Application No: LU/149/20/PL
Site Address: Littlehampton Wave Sea Road Littlehampton BN16 2NA
Description of works: Installation of a 4m high timber sculpture shaped in the form of 3 No. waves, fixed to a concrete base. This application is not CIL Liable (Zero Rated) as 'all other development'.

Thank you for your internet representation made on 22nd July 2020 which has been recorded as an objection with the comments as follows:

Drawing Title:
Plan & Elevation of Sculpture
Concrete Plinth

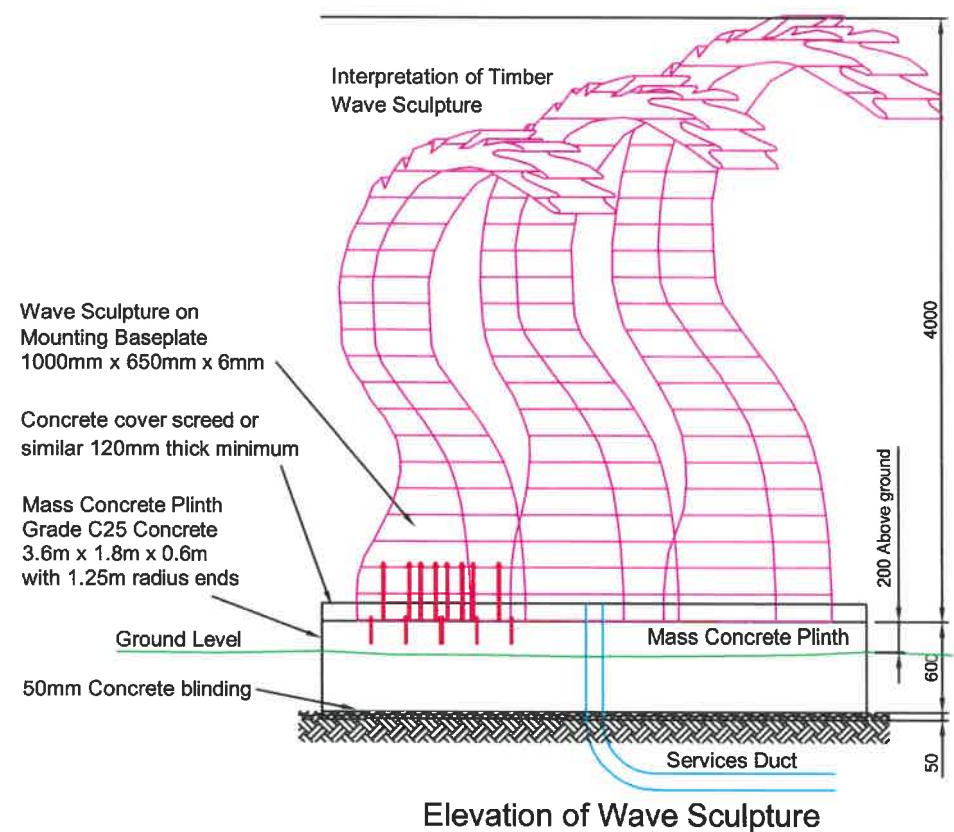
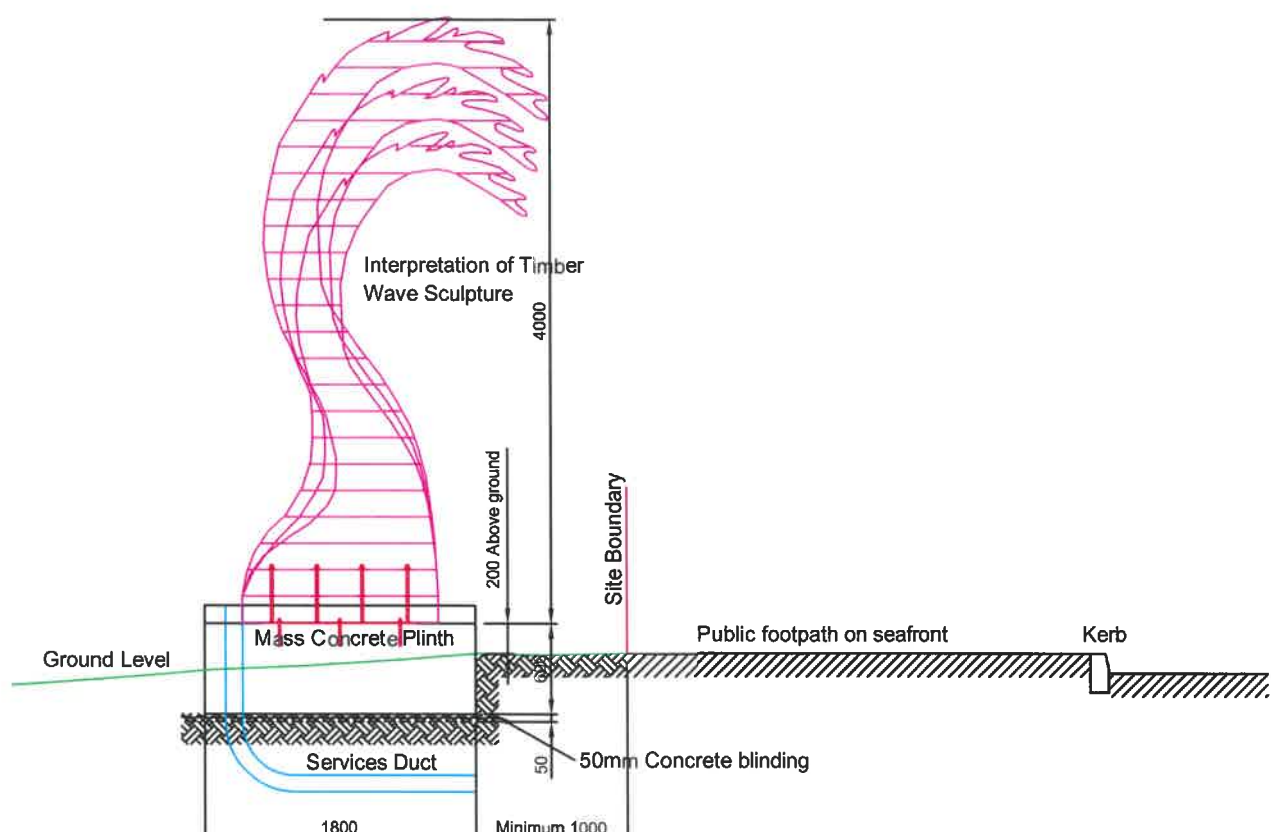
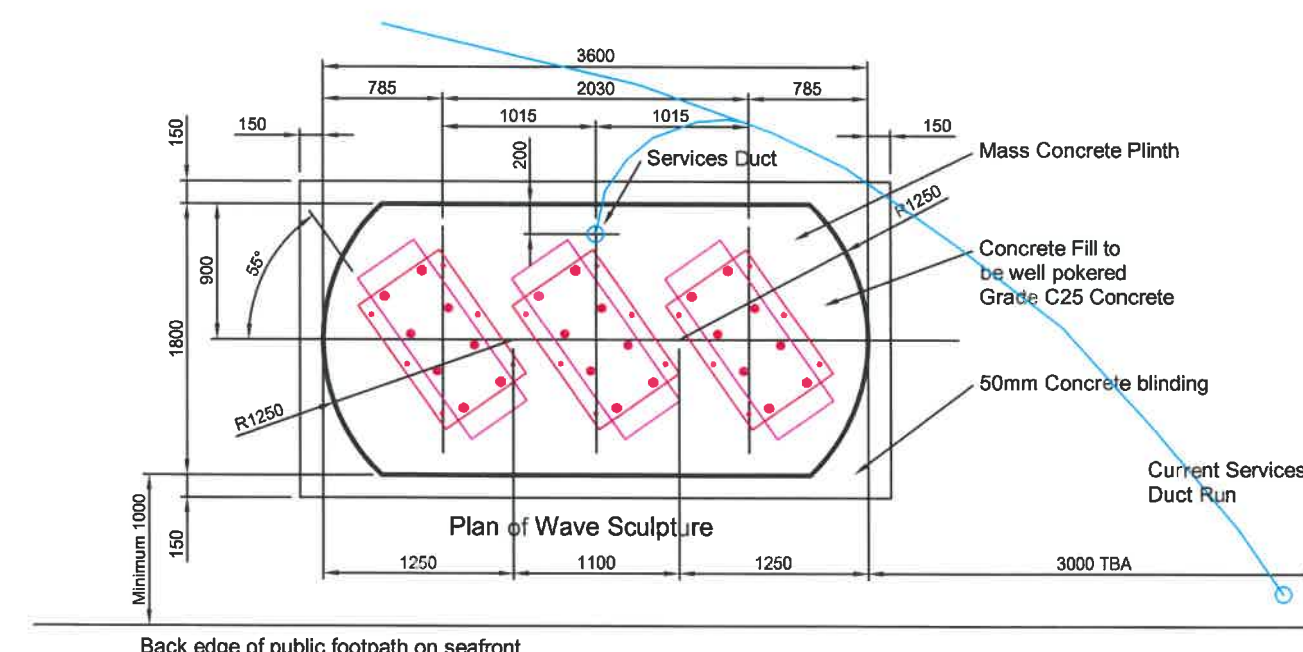
Further comment Interesting to see the Town Council has no objection even though they all thought the concrete plinth a monstrosity. They were told it was all part of the original plans for the Wave when permitted. Not true, I've just checked the statements on Design & Access and landscaping and no mention of it whatsoever. They were told it's already been built. For a Council that asks developers to consult the public at the very first stage of an idea well before submitting an application, why are they setting such a poor example by having done NO public consultation whatsoever for a piece of public art in the most prominent of public places. It's possible if they had they might have come up with something the community could be proud of, using the timber, rather than this. Possibly the cost of it was covered in the overall cost envelope of the centre. Disappointed at the Town Councils acquiescence.
